**KIRKLEES METROPOLITAN COUNCIL
INVESTMENT & REGENERATION SERVICE**

Reference No:	2025/62/93118/W
Site Address:	2, Acorn Drive, Meltham, Holmfirth, HD9 5AJ
Description:	Extension to existing driveway and installation of electric vehicle charging point
Recommending Officer:	Joshua Merriman

Officer Report – 2025/93118

scale	date	sheet size	dwg. no.
1:100	10/2025	A2	25/1262/04

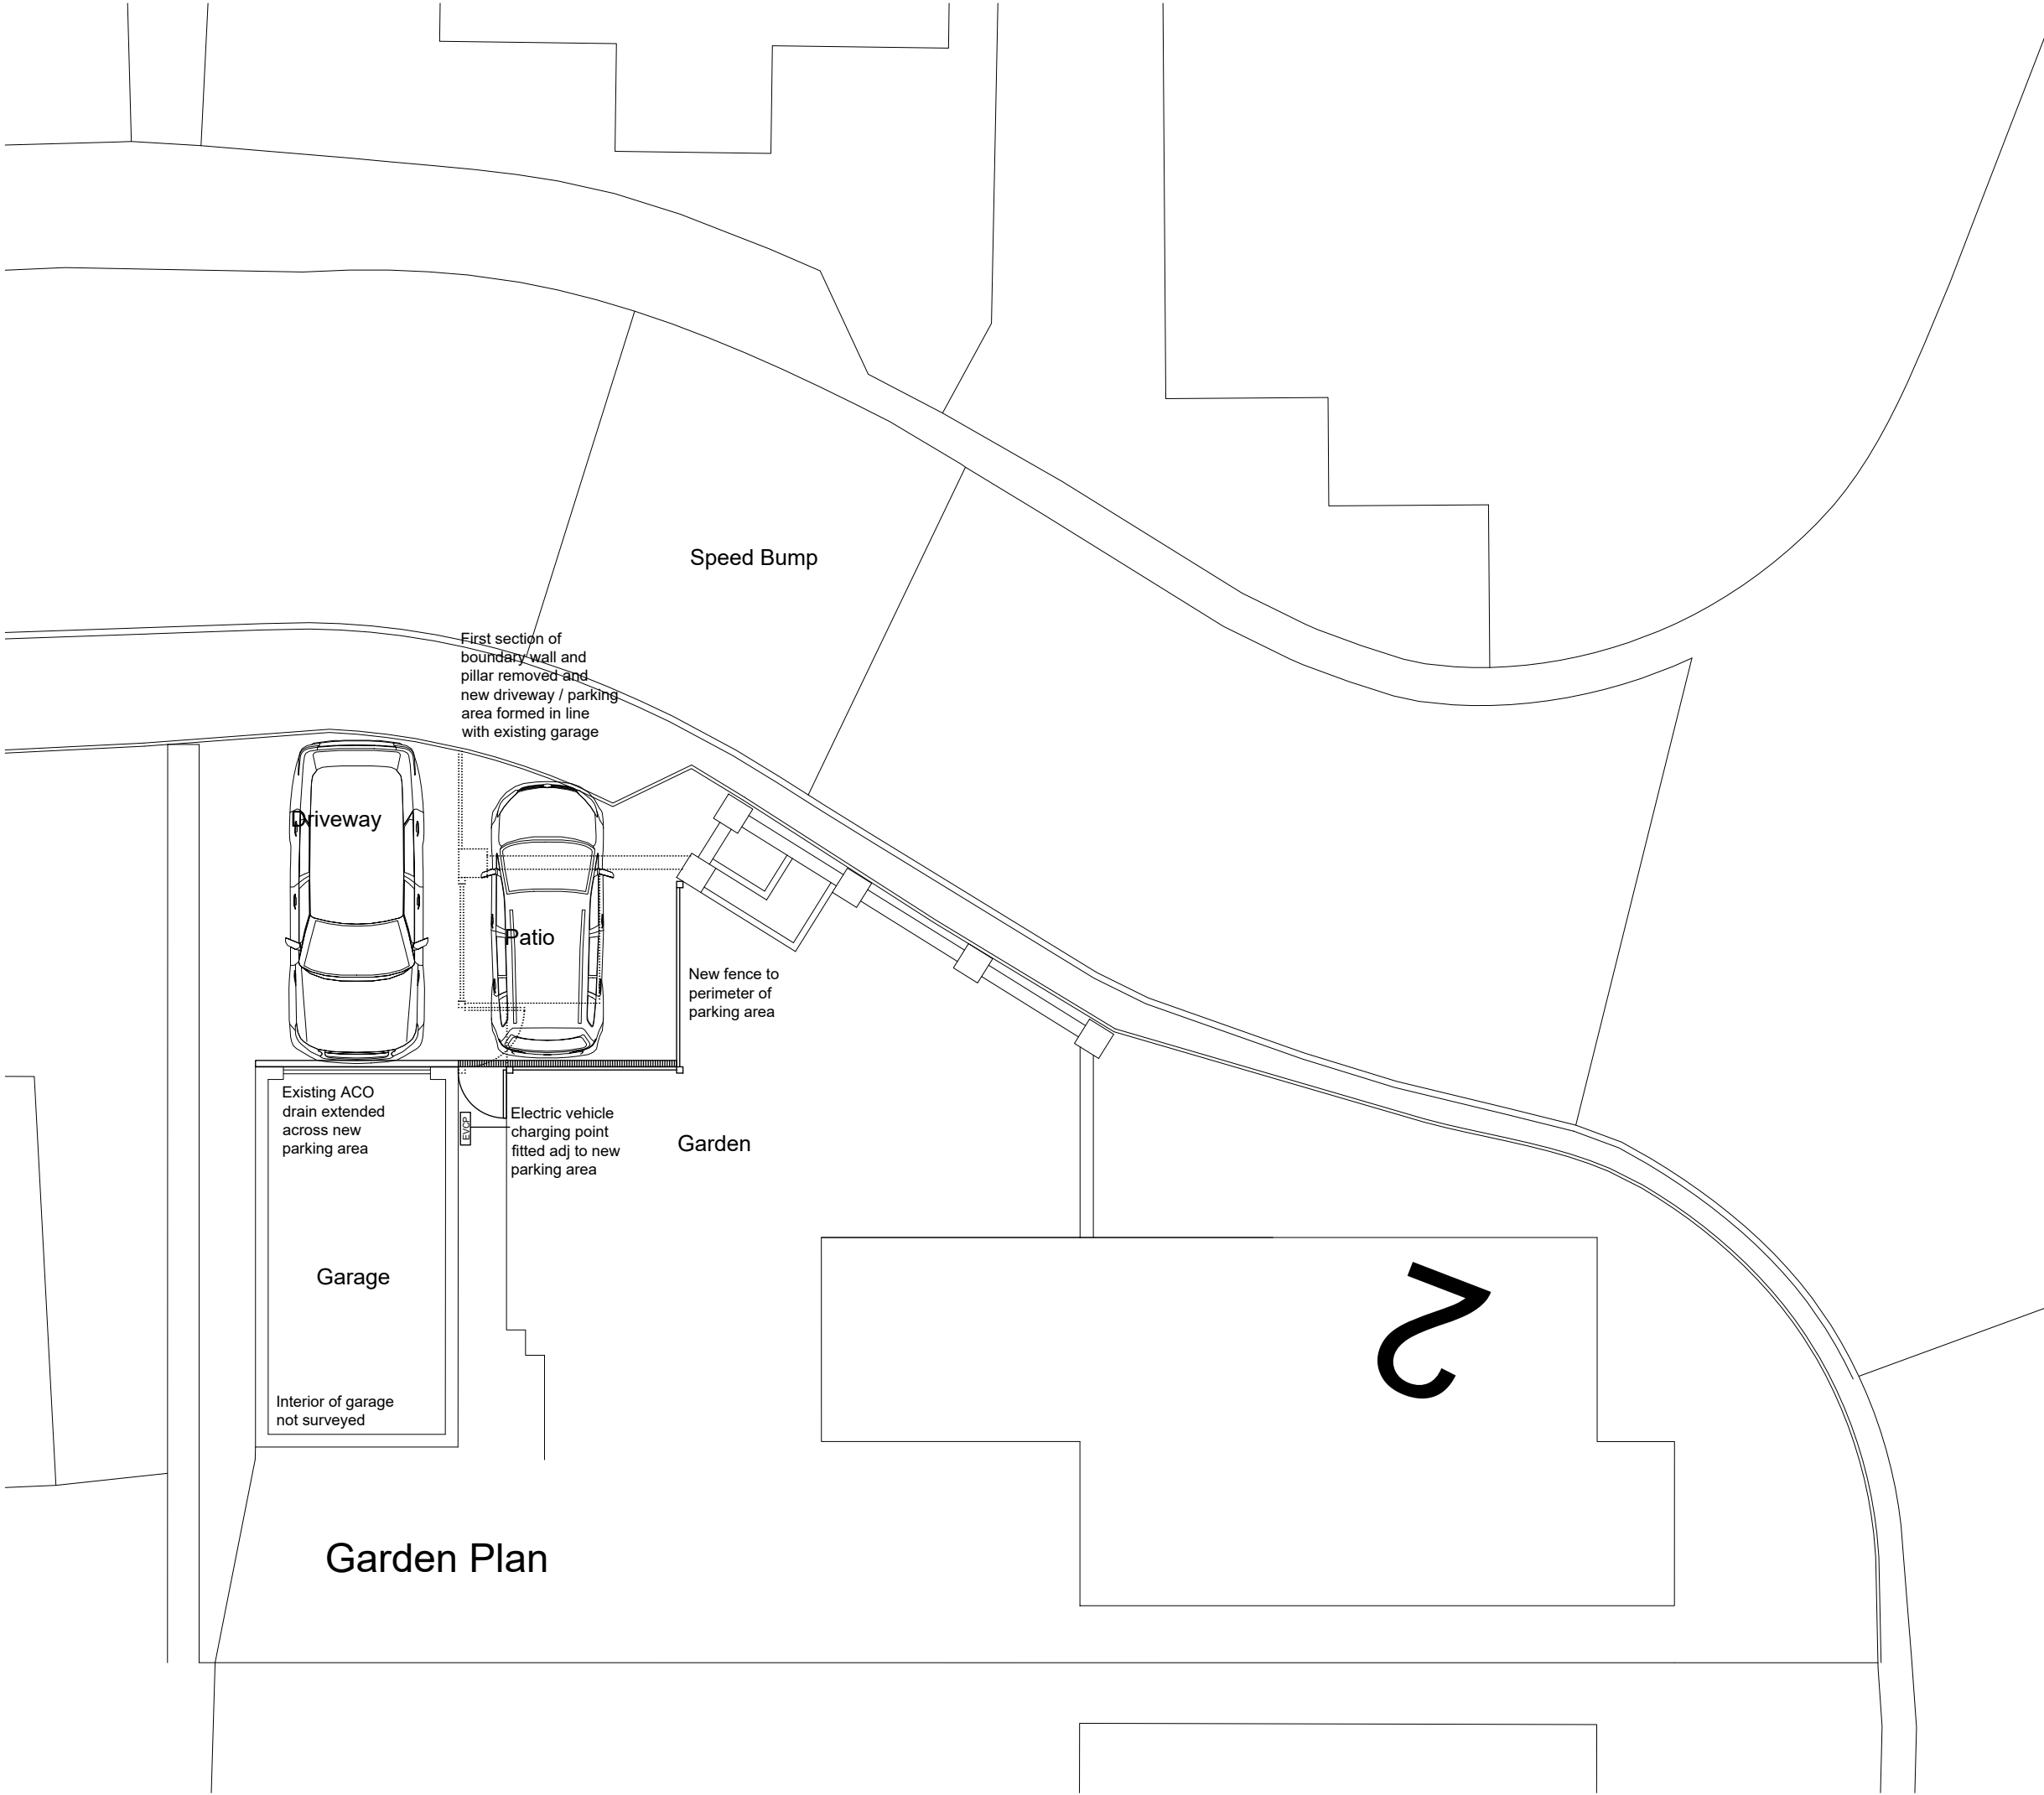
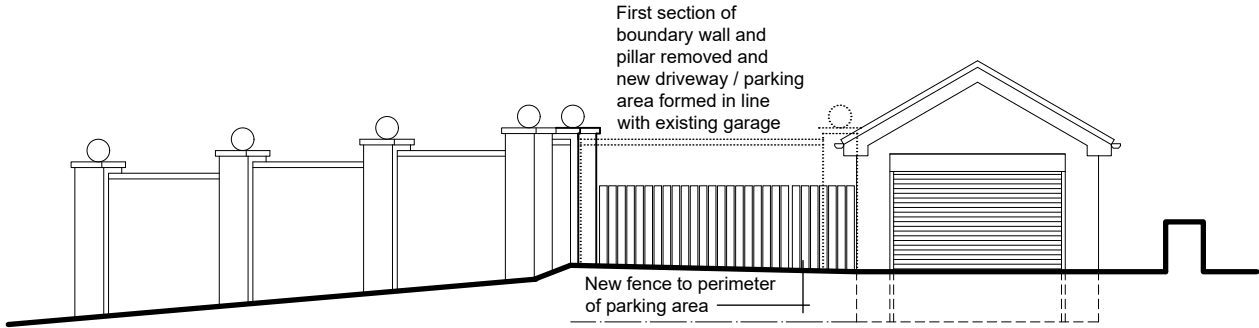
The case officer requested that the proposed driveway extension was increased in scale to ensure the second parking space on the hard-standing area was large enough to meet highways standards. Following the communication of this, the agent submitted amended plans showing a parking space that met highways space standards and was considered acceptable with regard to intervisibility in the context of the development and gains from the proposal.

- Meltham Town Council have expressed their support for the application subject to the fence line moving back and ensuring the car is not parked on the public pavement.

'After reviewing the revised plan, whilst the driver/pedestrian visibility splay to the right isn't drawn correctly and would provide a slight shortfall, I acknowledge the highway benefits of providing additional off-street parking, which will provide parking for the Applicants second vehicle, which is currently parked on street. It is considered that in practice pedestrians walking on the shared surface approaching the proposed driveway are likely to be walking in the order of a 0.5m to 1m from the edge of the carriageway and so adequate driver/pedestrian

Officer Comment: Noted, the space has been increased in size to prevent the vehicle utilising the space overhanging the pavement.

scale date sheet size dwg. no.  
1:100 10/2025 A2 25/1262/04a

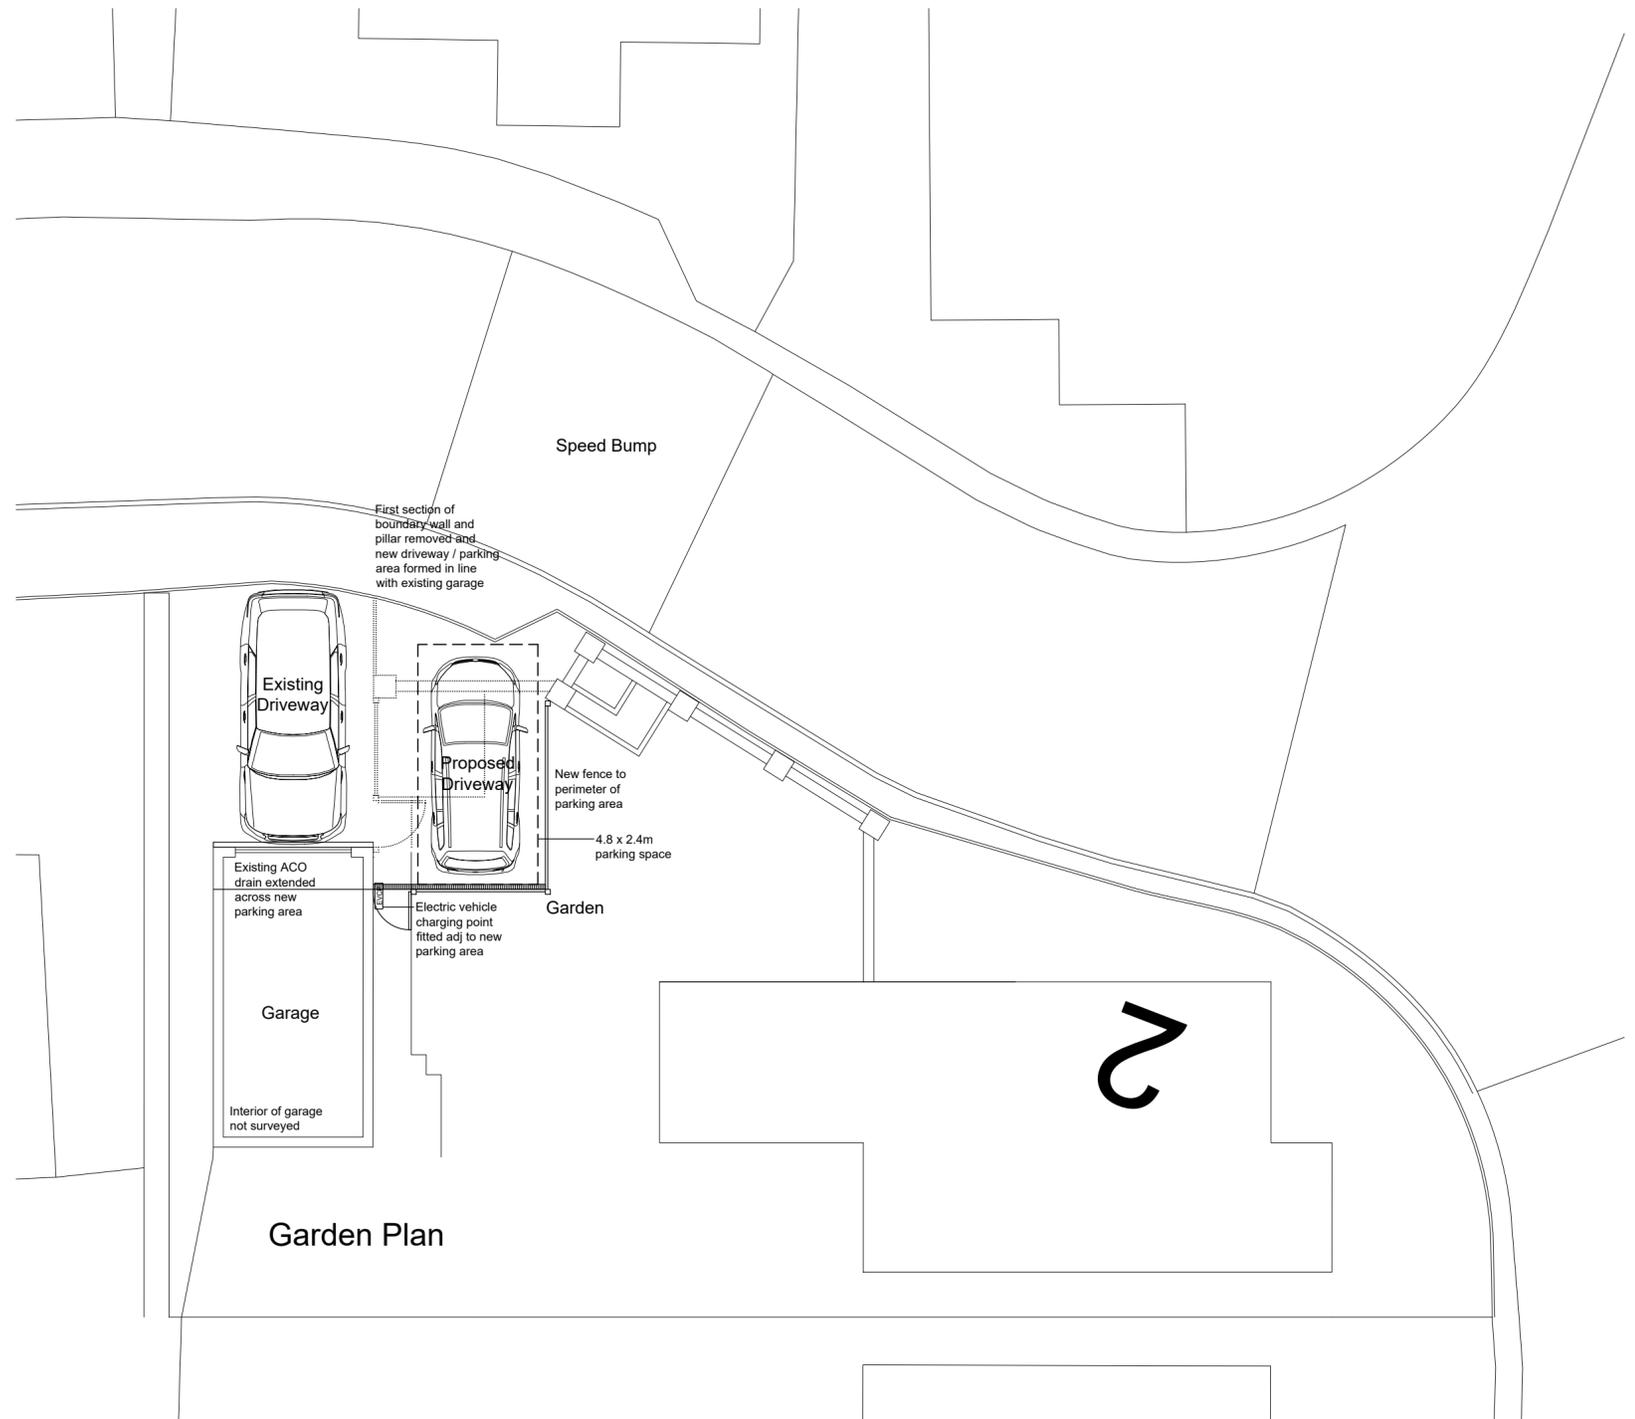
intervisibility would be provided. Following further consideration HDM have no objection to the proposal.'

15/12/2025 – Proposed Plans and Elevations – 25/1262/04a
